Lime Down Solar

I have been trying to follow Lime Downs updates on their HGV and roadwork proposals for the main two routes to the Solar sites.

Whilst the transport Response C ([REDACTED]) appears very comprehensive and detailed , it also seems to be based on a flawed assumption in their Purpose of Assessment which states — may have sections where two HGV's cannot comfortably pass. The road from the approaches to Hullavington to site D is not wide enough for two HGV's to pass .

Title: Figure 8-12-4: Transport Receptors
Lime Down D

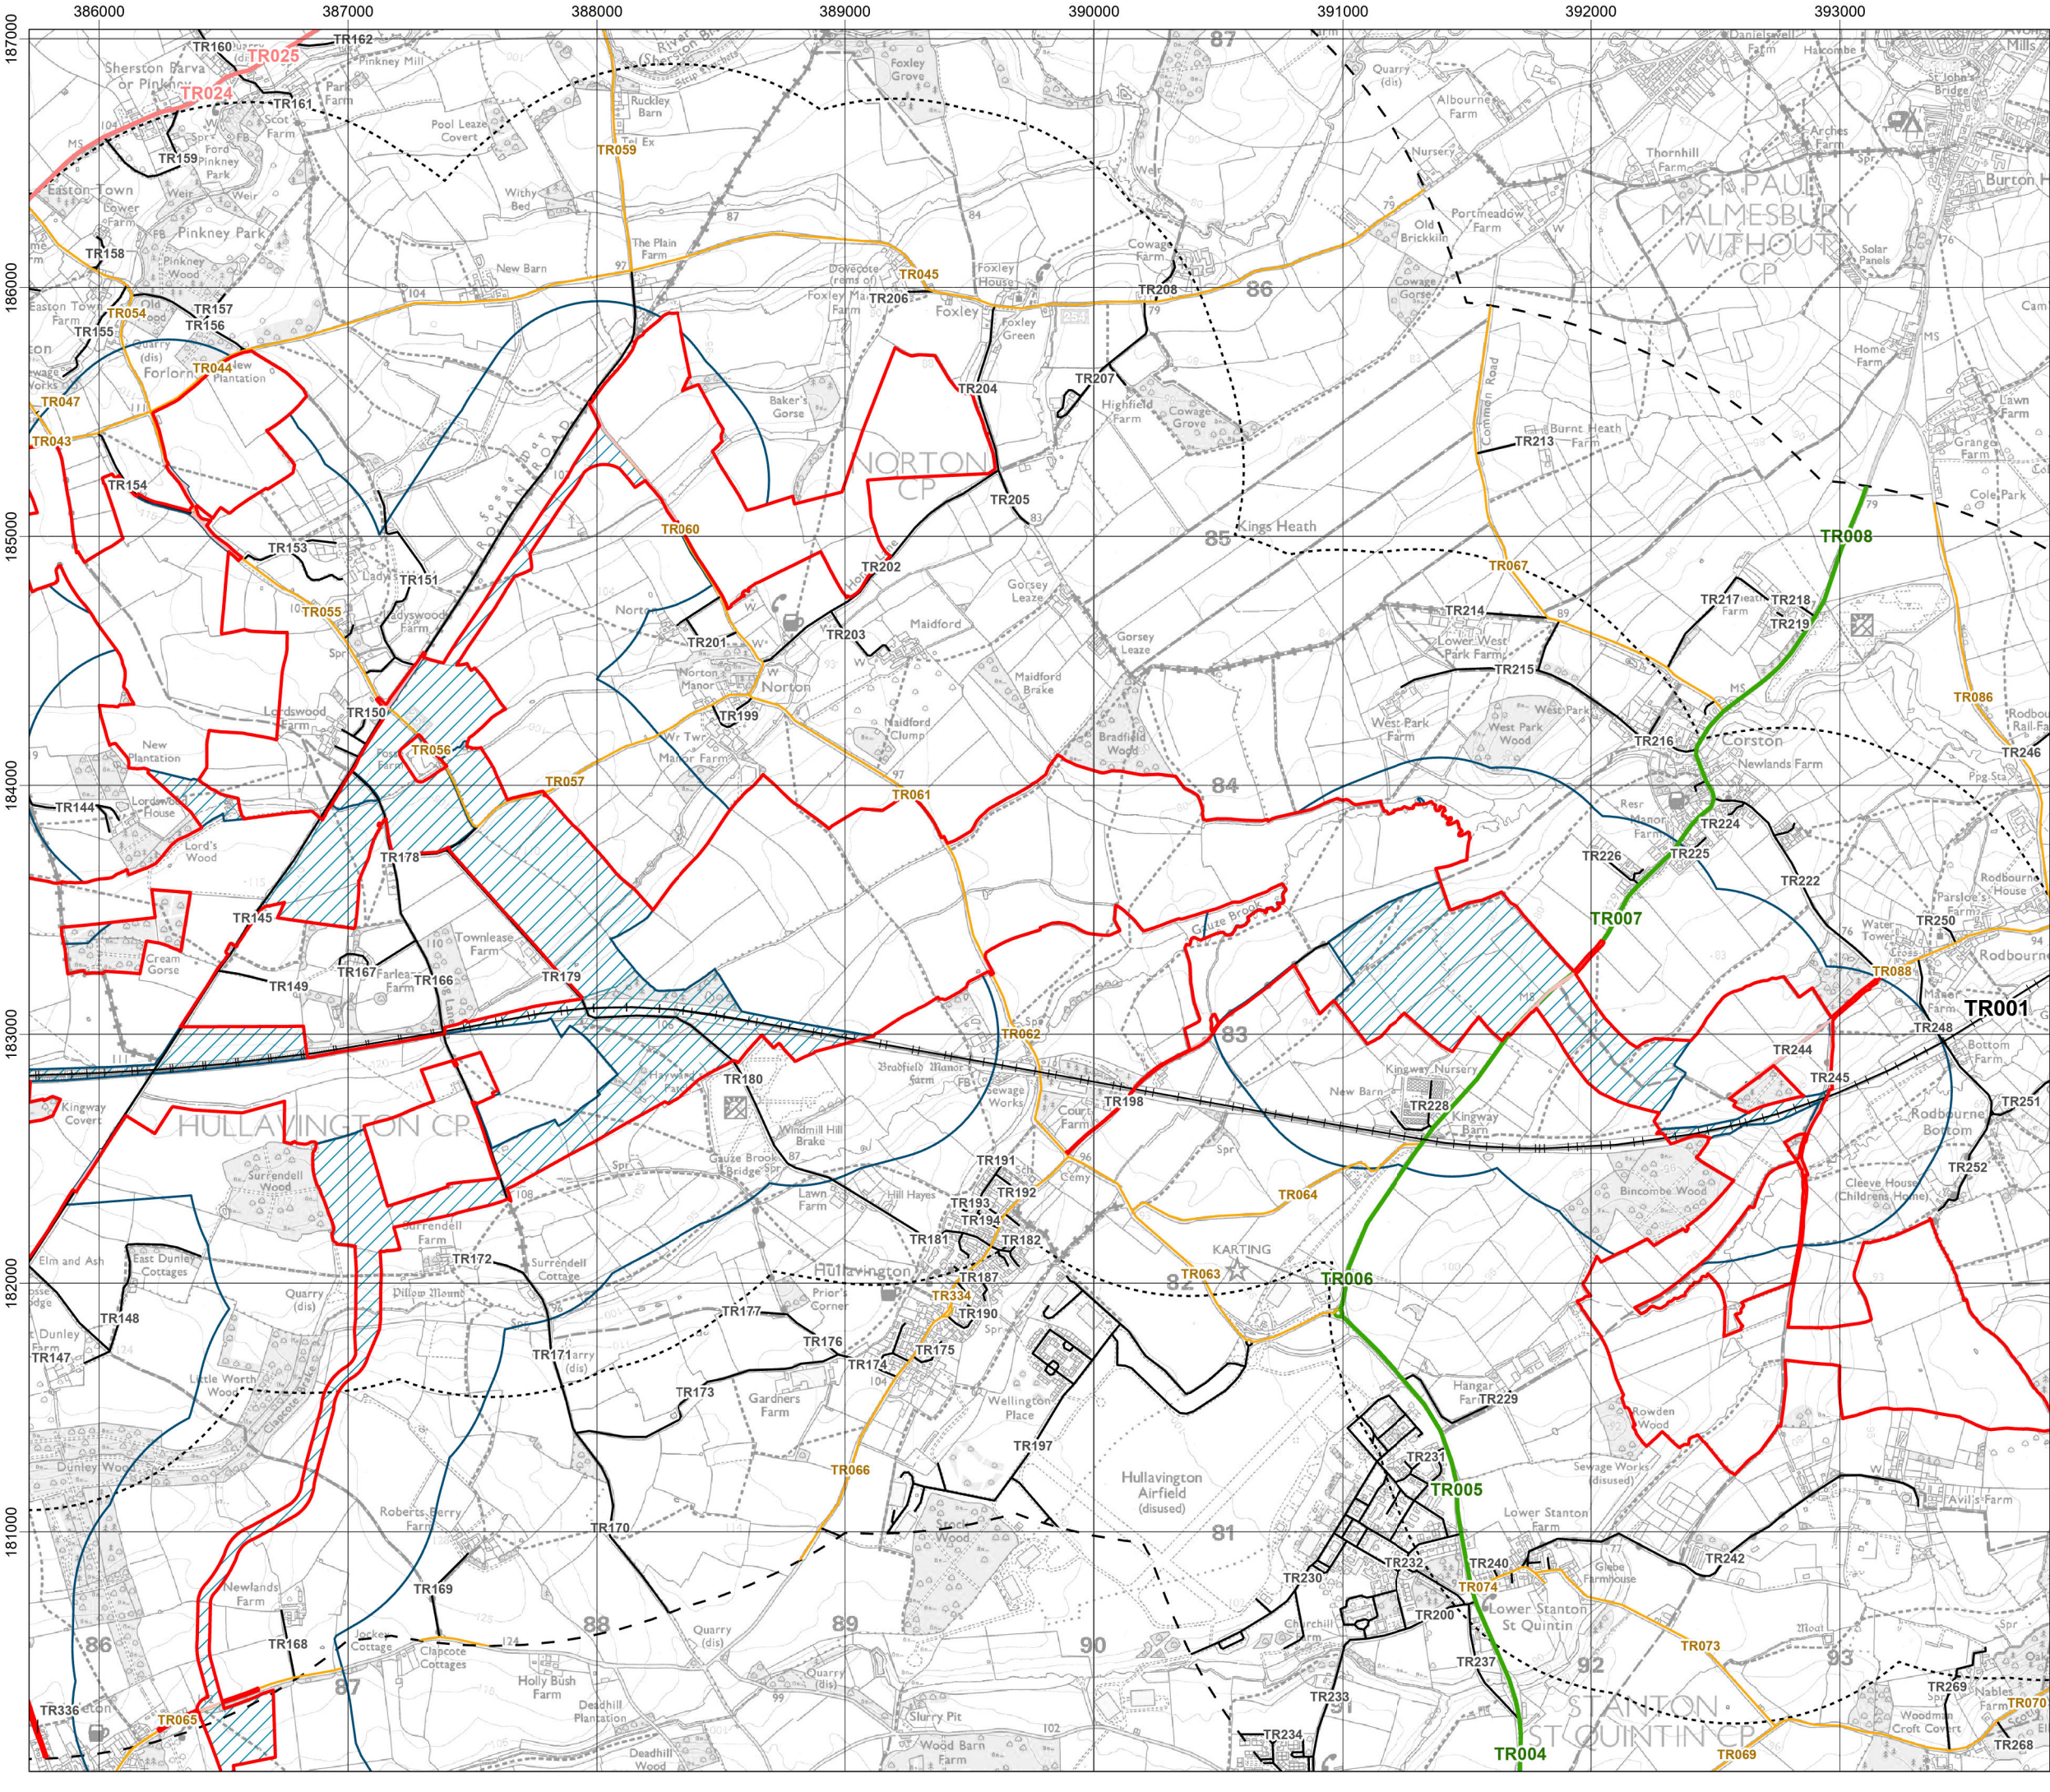
This was demonstrated earlier in the year during the construction of the housing estate on the corner of the Street at Hullavington. HGV construction vehicles were either held in the Street , or waiting at the side of the road in front of the BT substation for a gap in oncoming traffic , before proceeding . HGV or any large construction vehicles approaching from the south , similarly relied on oncoming vehicles to pull over in order for them to pass.

Lime Downs assessment fails to recognise this or that other wide vehicles such as the bus service , recycling lorries and numerous other vehicles also use this route. Their assumption that HGV vehicles using this route would pass at an average speed of 25mph therefore also seems highly unlikely.
